Response to Planning Application

From: Arun District Council Greenspace

Application ref: AL/66/21/PL

Description: 1 No new dwelling & detached hydrotherapy pool house along with associated external works & creation of 1 No additional vehicular entrance

Sundown
Appendix 2- tree protection plan

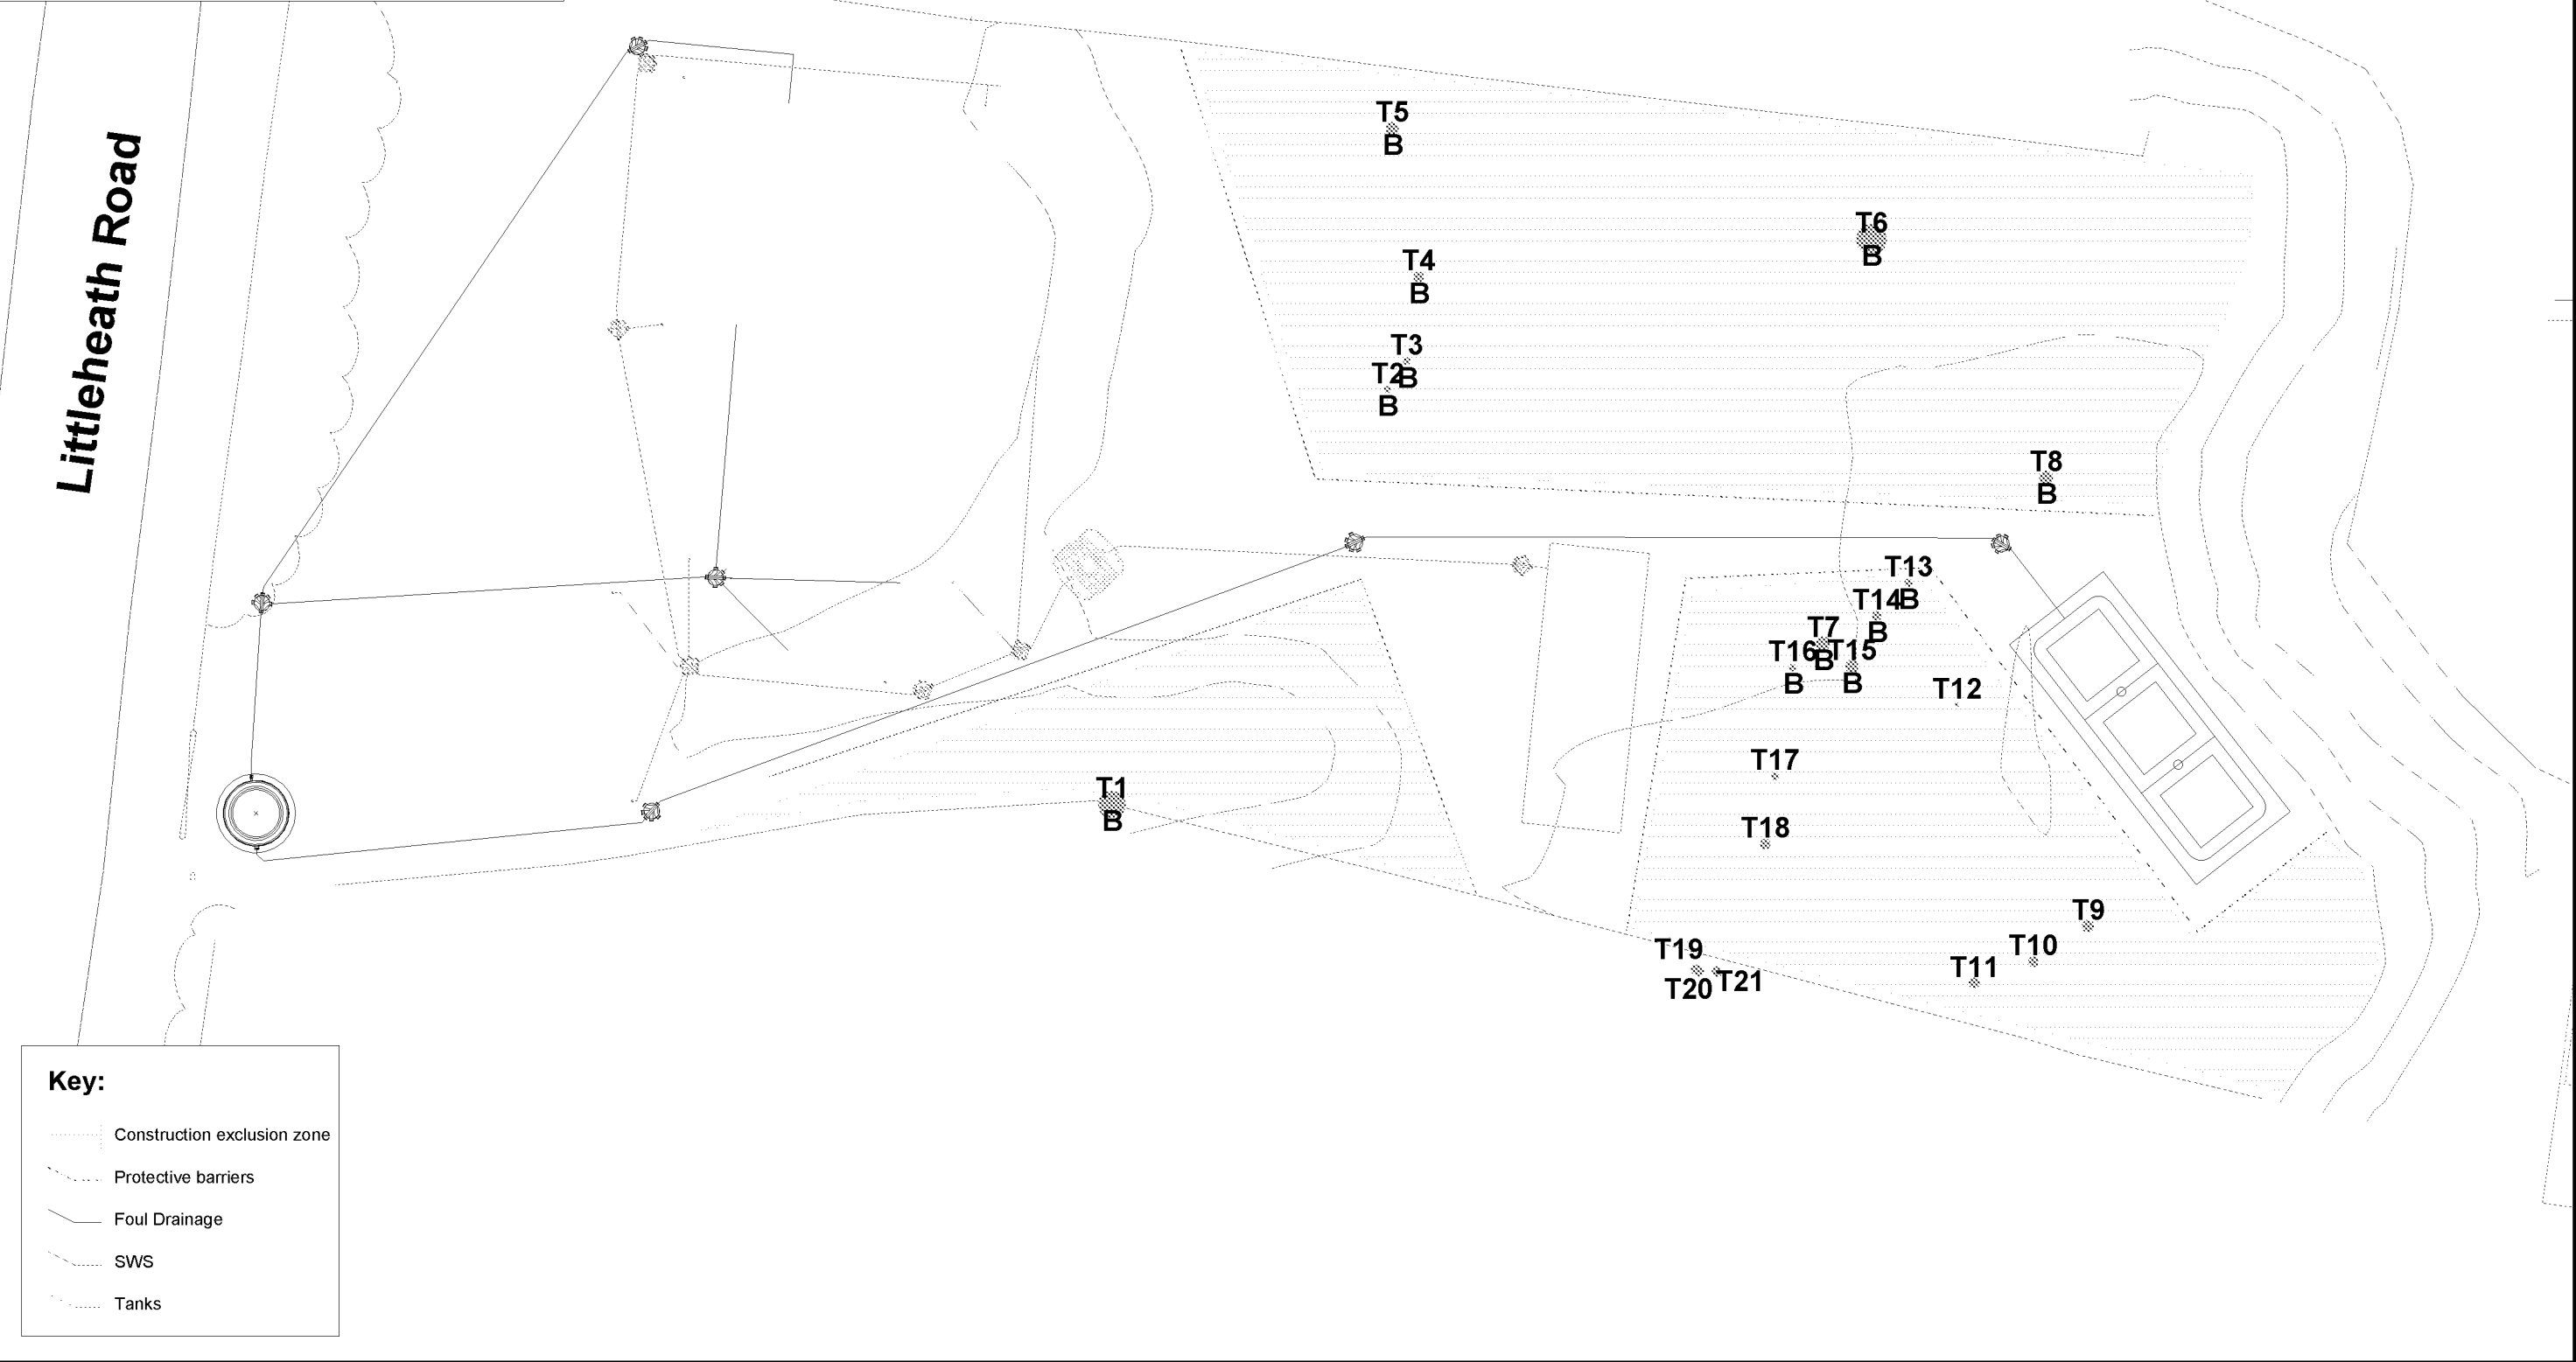
The NPPF para 124/127 relate to good design principles which equally apply to small infill and replacement development. The indicative site layouts and tree protection plans has made reference to indicative planting alongside tree retention. These details would require expanding in the form of a detailed planting plan and specification detailing species choice, actual plant quantities, planting densities and size at time of planting.

Landscape provision to the dwelling and improvement with native species infill plus further boundary screening as required. All proposed planting should be considered and its connection for biodiversity and habitat explored, with a biodiversity net gain following development. Trees specified should be at a size which allow instant impact, but which will establish and mature as the site develops.
